PERMIT ISSUED
Permit Number: 051122
SEP - 8 2005
CITY OF PORTLAND

Project: Allen Residence, 101 River's Edge Or, Portland

ADDENDUM NO. 1**DRAWINGS & SPECIFICATIONS**

**ALLEN RESIDENCE
101 RIVER'S EDGE DRIVE
PORTLAND ME 04102**

EXTERIOR  
ELEVATIONS  
**A-2**

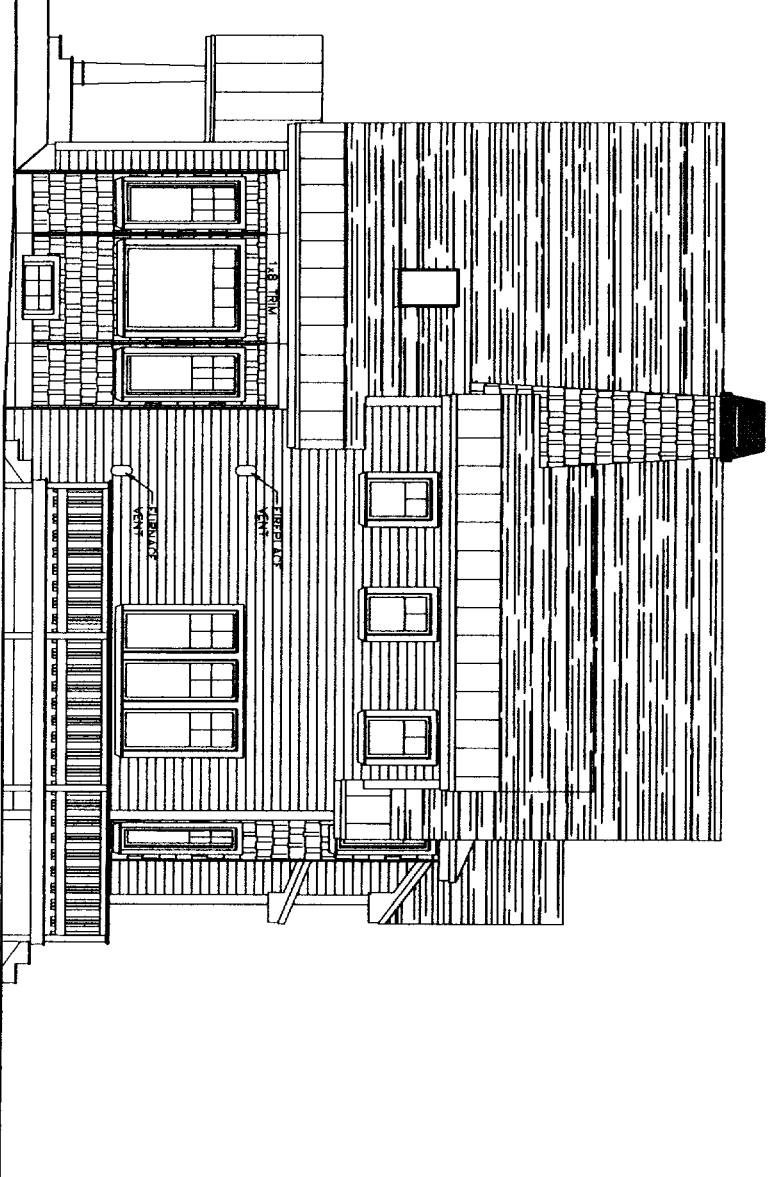
Item 2: Drawing A-2

DELETE side wall vents for fireplace and boiler. Utilize chimney for venting. Provide Metalbestos insulated flue system designed for the boiler type. Napoleon gas stove comes with a proprietary exhaust/ intake flue system. Adjust chase space as required to accommodate 30 degree flue off sets through MBR Closet.

**A-3**

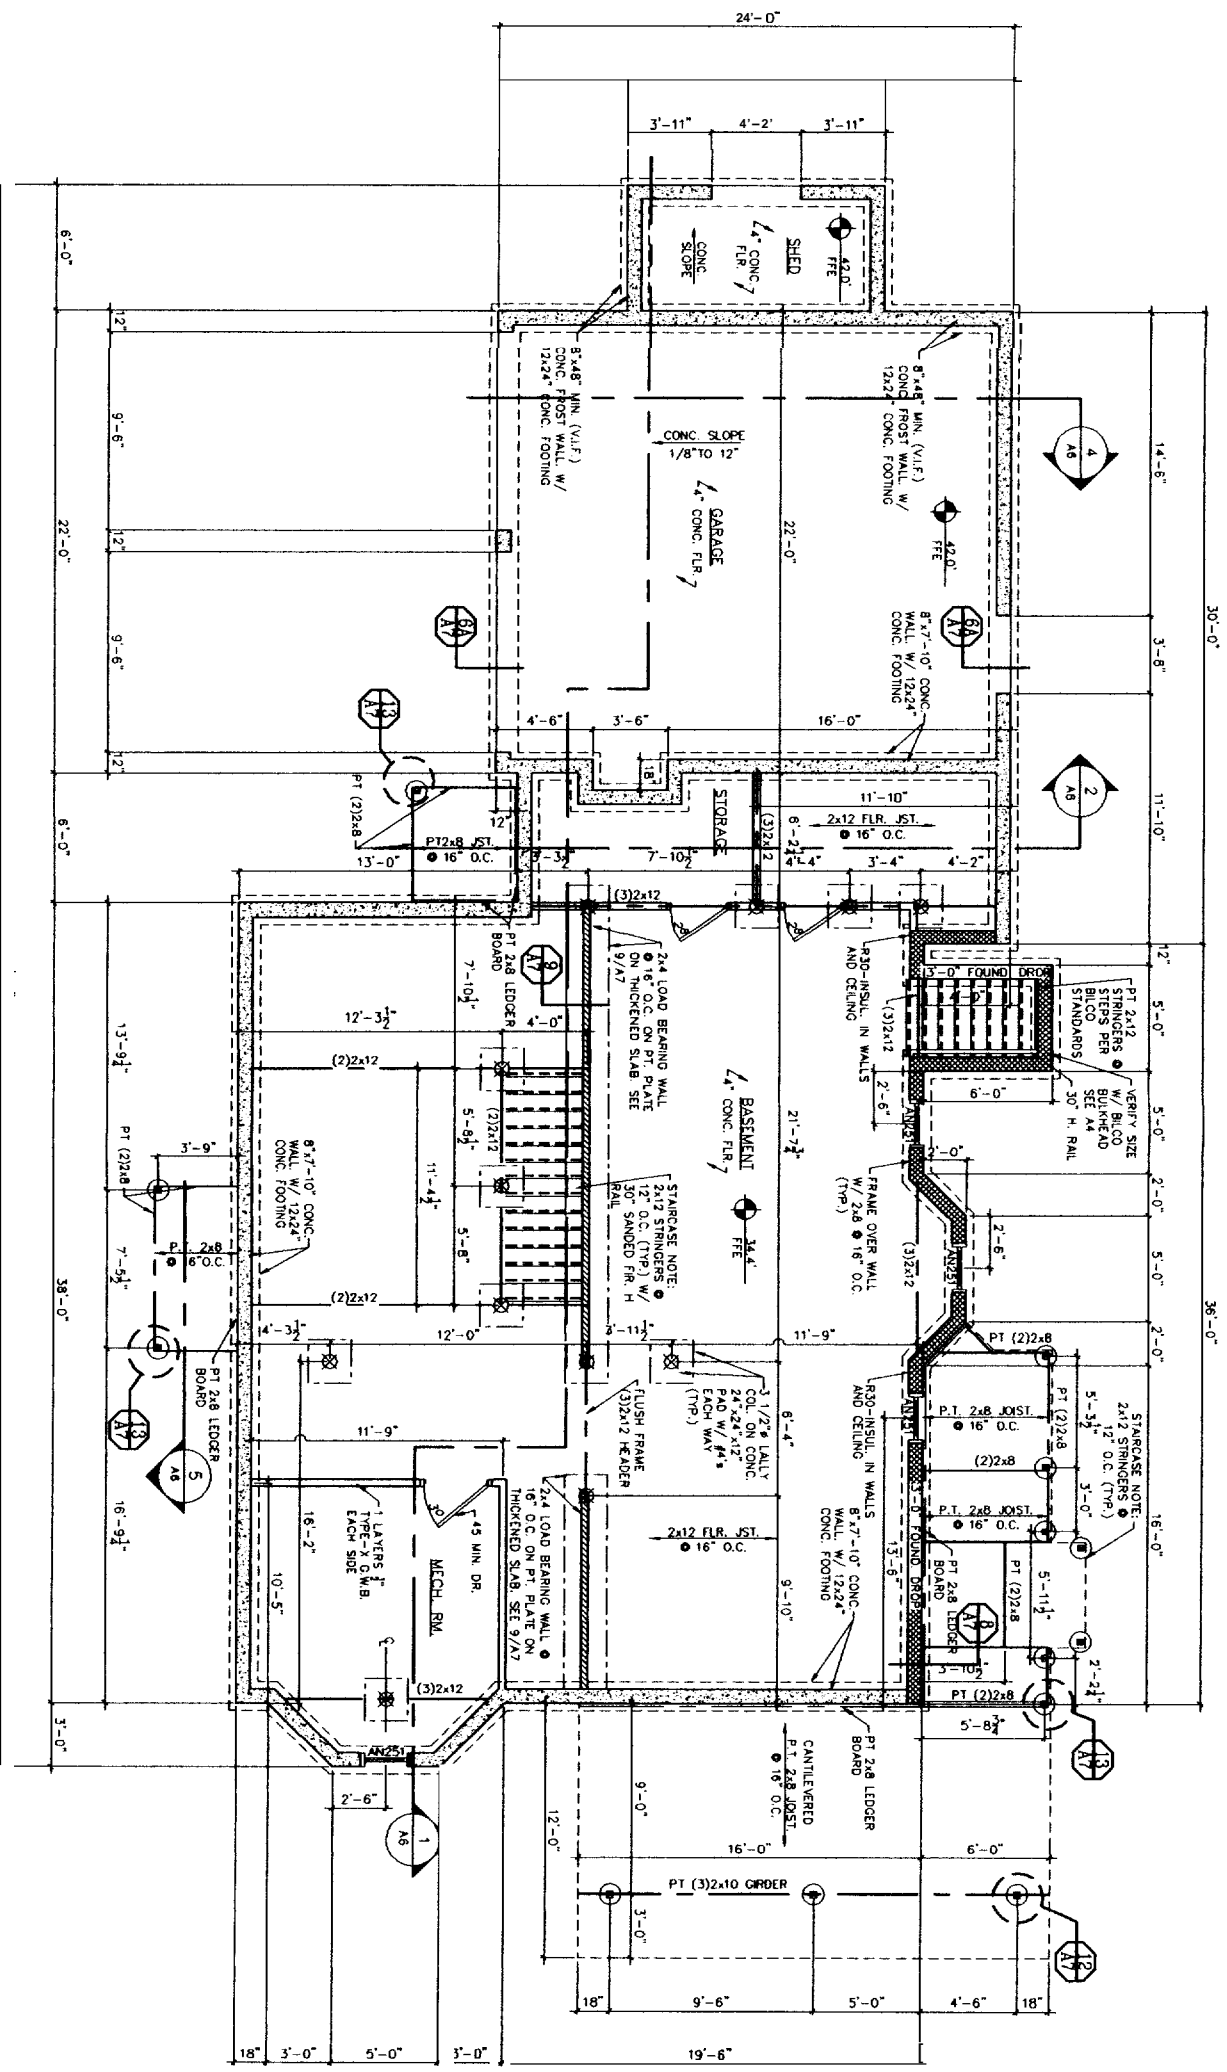
Item 3: Drawing A-3

CHANGE R-30 to R-19- 2 locations

code
Item 4: Drawing A-3

Provide interconnected smoke detector system, 1 per floor, 1 each bedroom (7 total)

Item 5: Drawing A-3

Provide (4) residential sprinkler heads off the domestic cold water lines, Mech- exposed, Kit, LR, FR- concealed

Item 8: Drawing A-3

Basement Playroom with bulkhead to be finished with gwb and lay-in ceiling per spec.

Item 6: Drawing A-3
CHANGE R-30 to R-21- 2 locations, ADD 'Entire Ceiling'.

SECOND FLOOR PLAN  
**A-5**

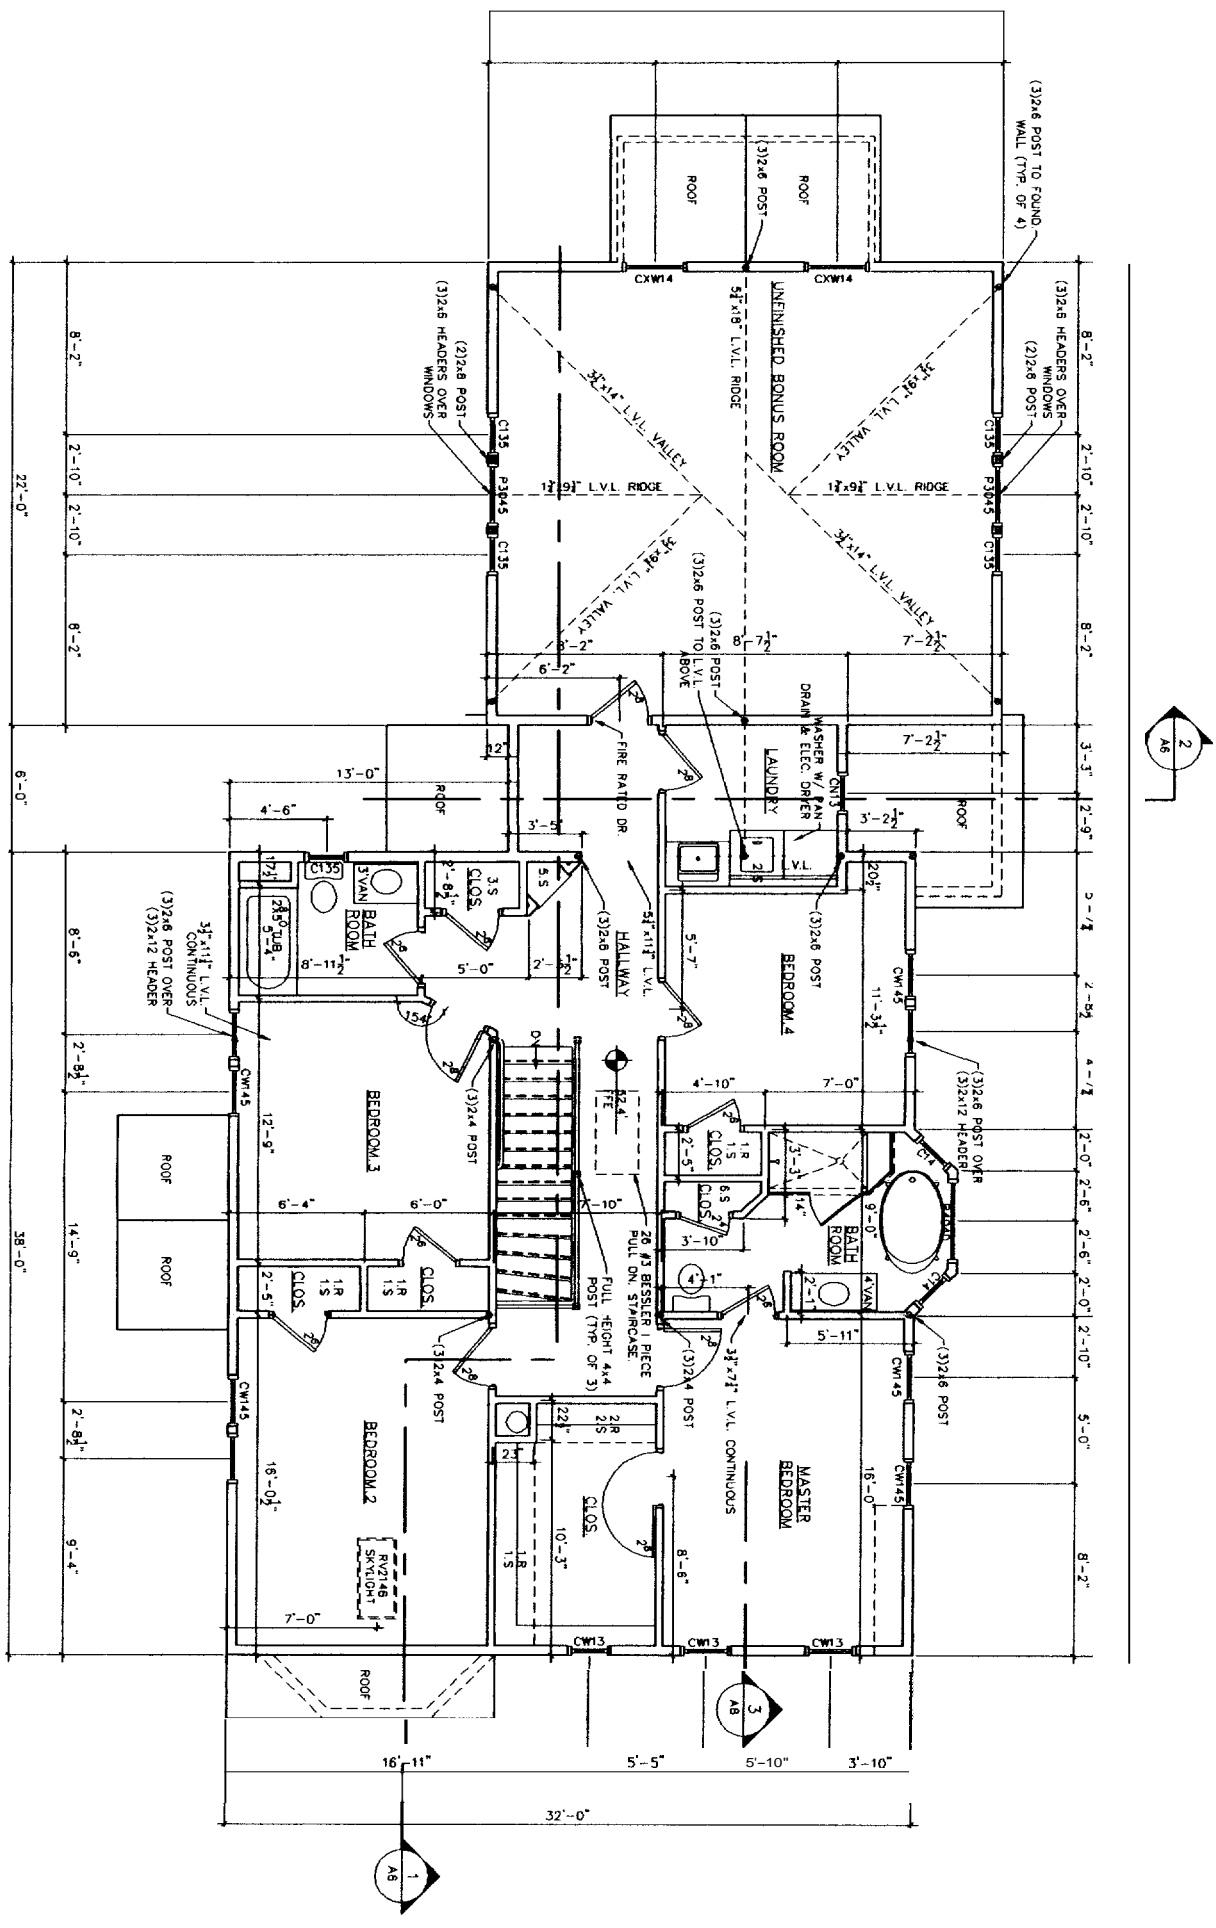
code
Item 9: Drawing A-5
(3) windows adjoining the MBath whirlpool to be tempered glass.

Item 10: Drawing A-5
Provide 2 pair 2—C135 windows at opposite ends of the attic space.

BUILDING SECTIONS  
**A-6**

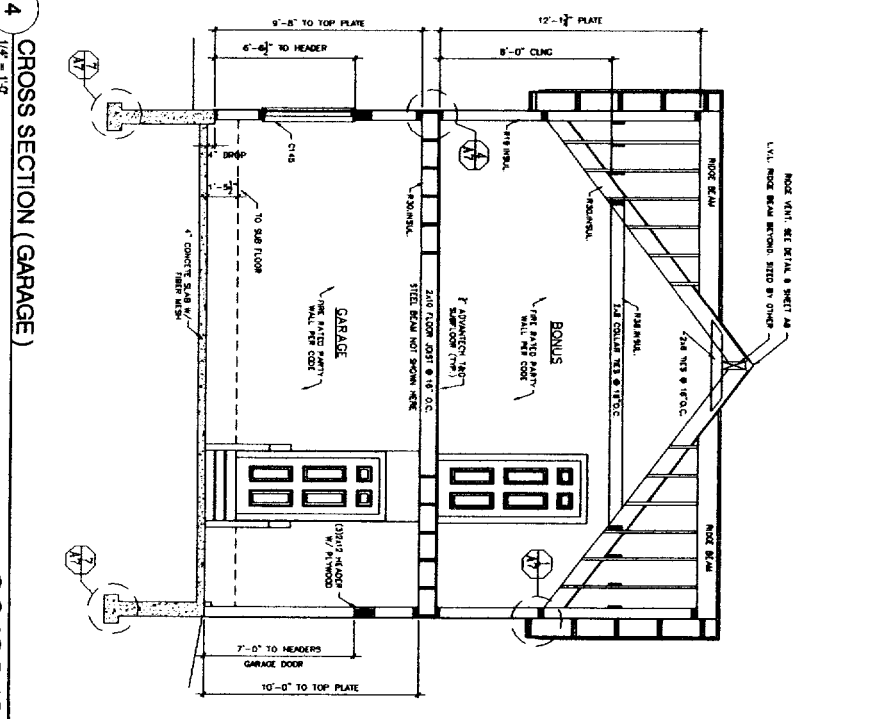
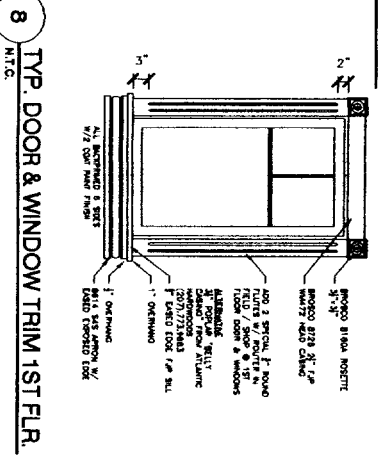
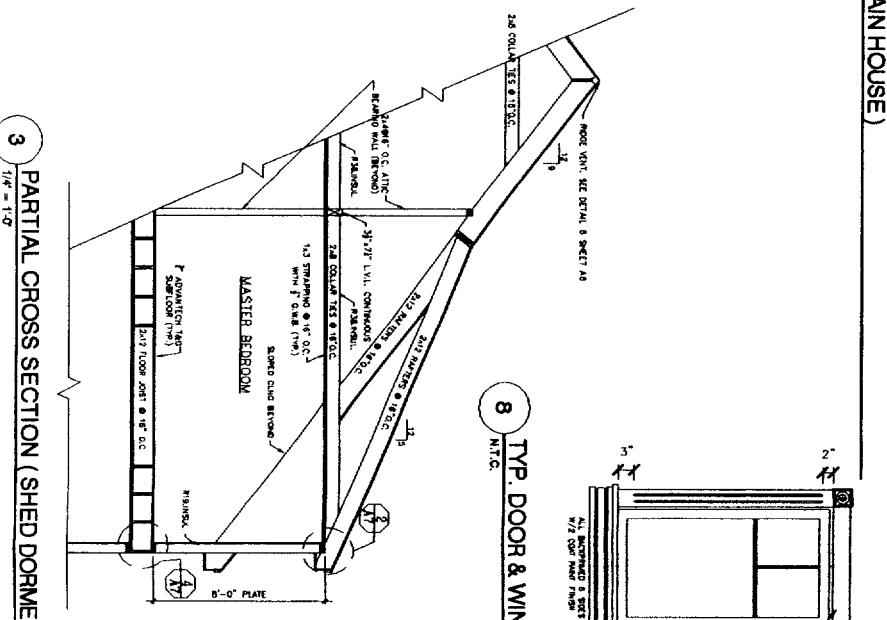
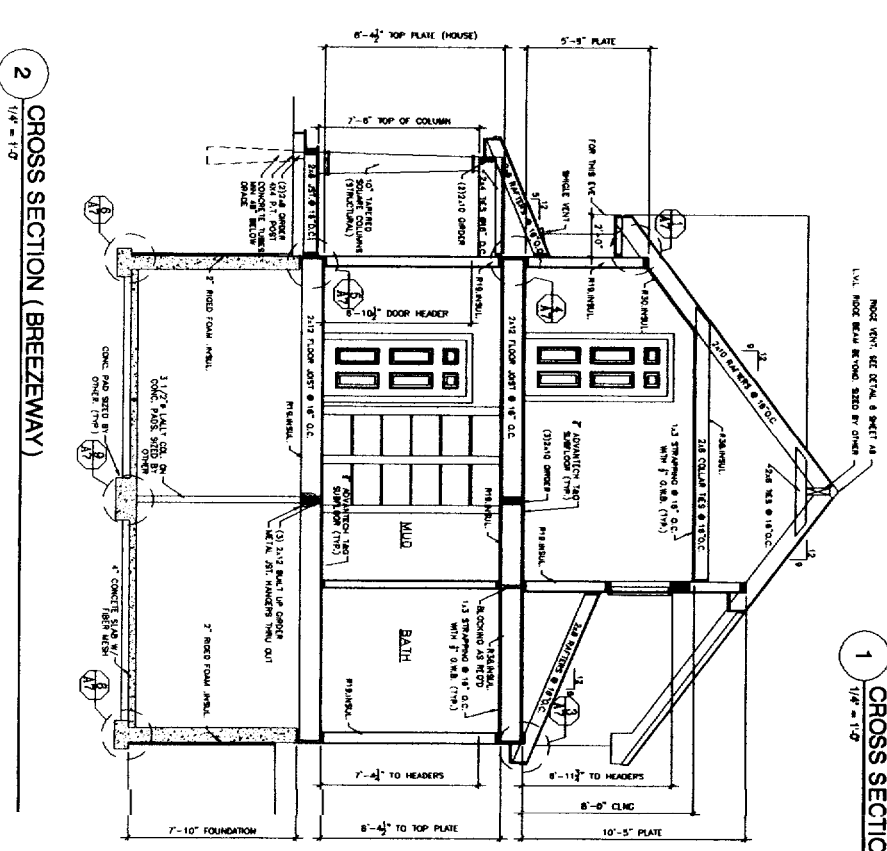
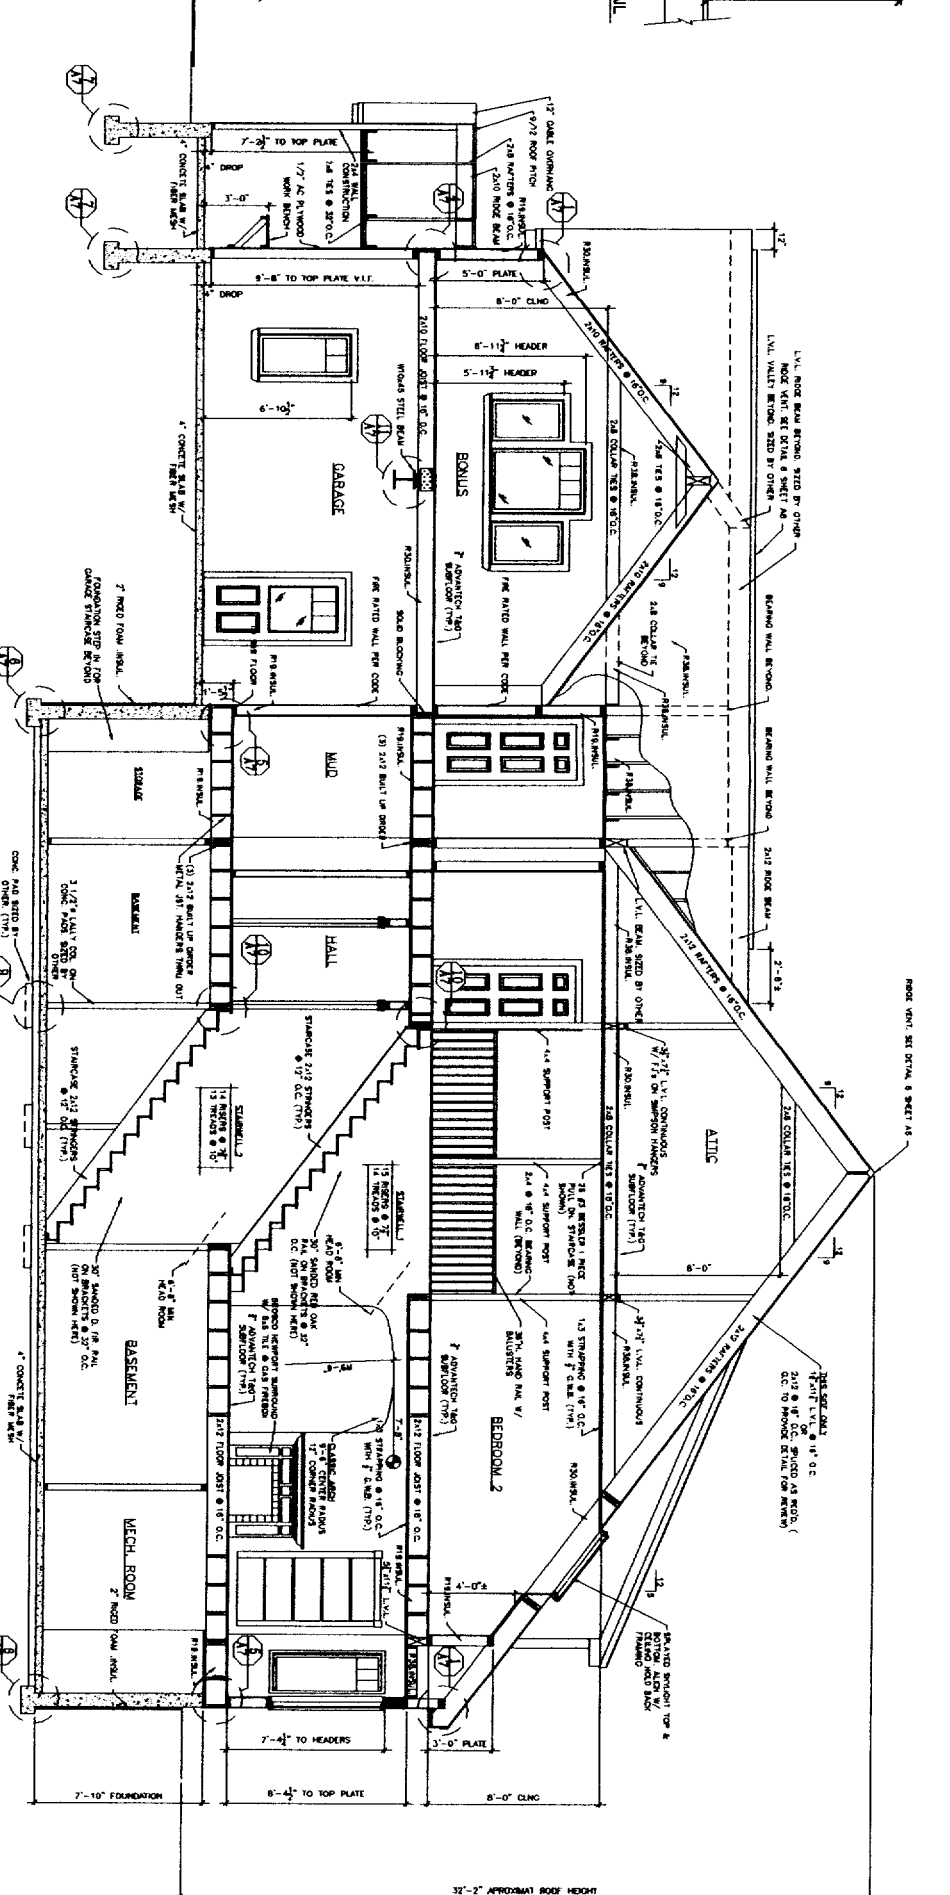
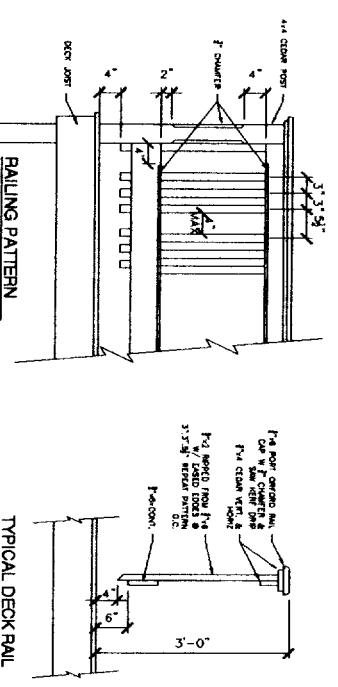
CODE
Item 11: Drawing A-6
REVISE both stair handrails from 30" to 34". All ends to return to wall.

Item 12: Drawing A-6
DELETE 'rigid' and REPLACE with 'rigid' (4) locations.

**11 STEEL BEAM DETAIL**  
 AT 3/4" = 1'-0"

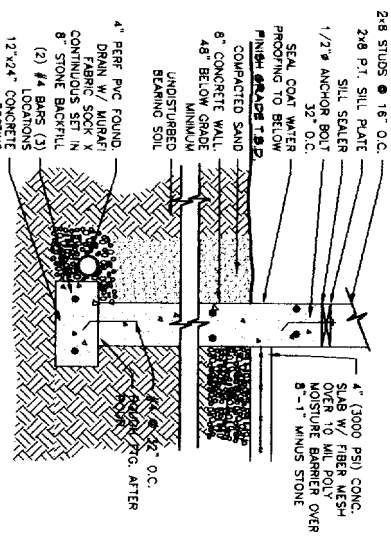
CODE
Item 13: Drawing 11/A-7
Show 5/8" type-X GWB and wrap steel beam with same.

**12 CANTILEVERED DECK DETAIL**  
 AT 3/4" = 1'-0"

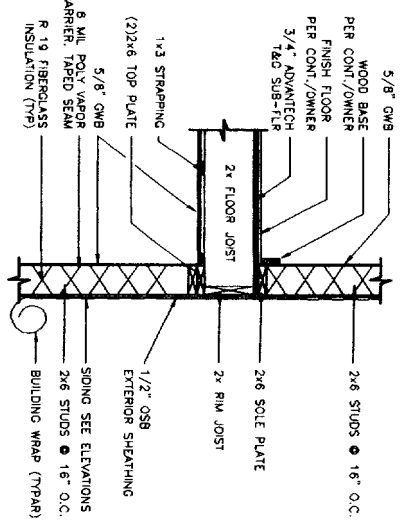
CODE
Item 14: Drawing 12/ A-7
Provide PT solid blocking between deck joists above beam at cantilever.

**8 SLAB & FOUND. WALL DETAIL (DAYLIGHT)**  
 AT 3/4" = 1'-0"

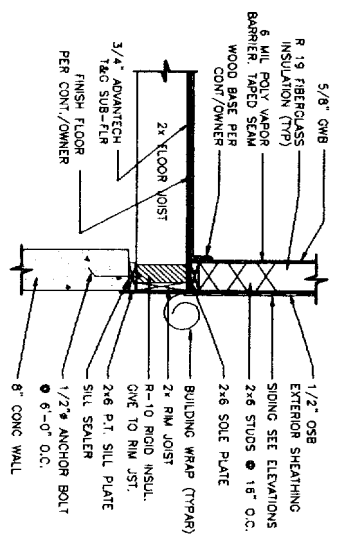
CODE
Item 15: Drawing 8/ A-7
Provide 2" rigid insulation at exterior to top of concrete (similar to 6B/A-7)
and add R-19 batt insulation vertical for continuous insulated exterior wall.
Cover 2" rigid insulation with soil. Finish interior with GWB.

Item 7: Drawing 8/ A-7
Provide 2" rigid insulation at exterior to top of concrete (similar to 6B/A-7)
and add R-19 batt insulation vertical for continuous insulated exterior wall.
Cover 2" rigid insulation with soil. Finish interior with GWB.
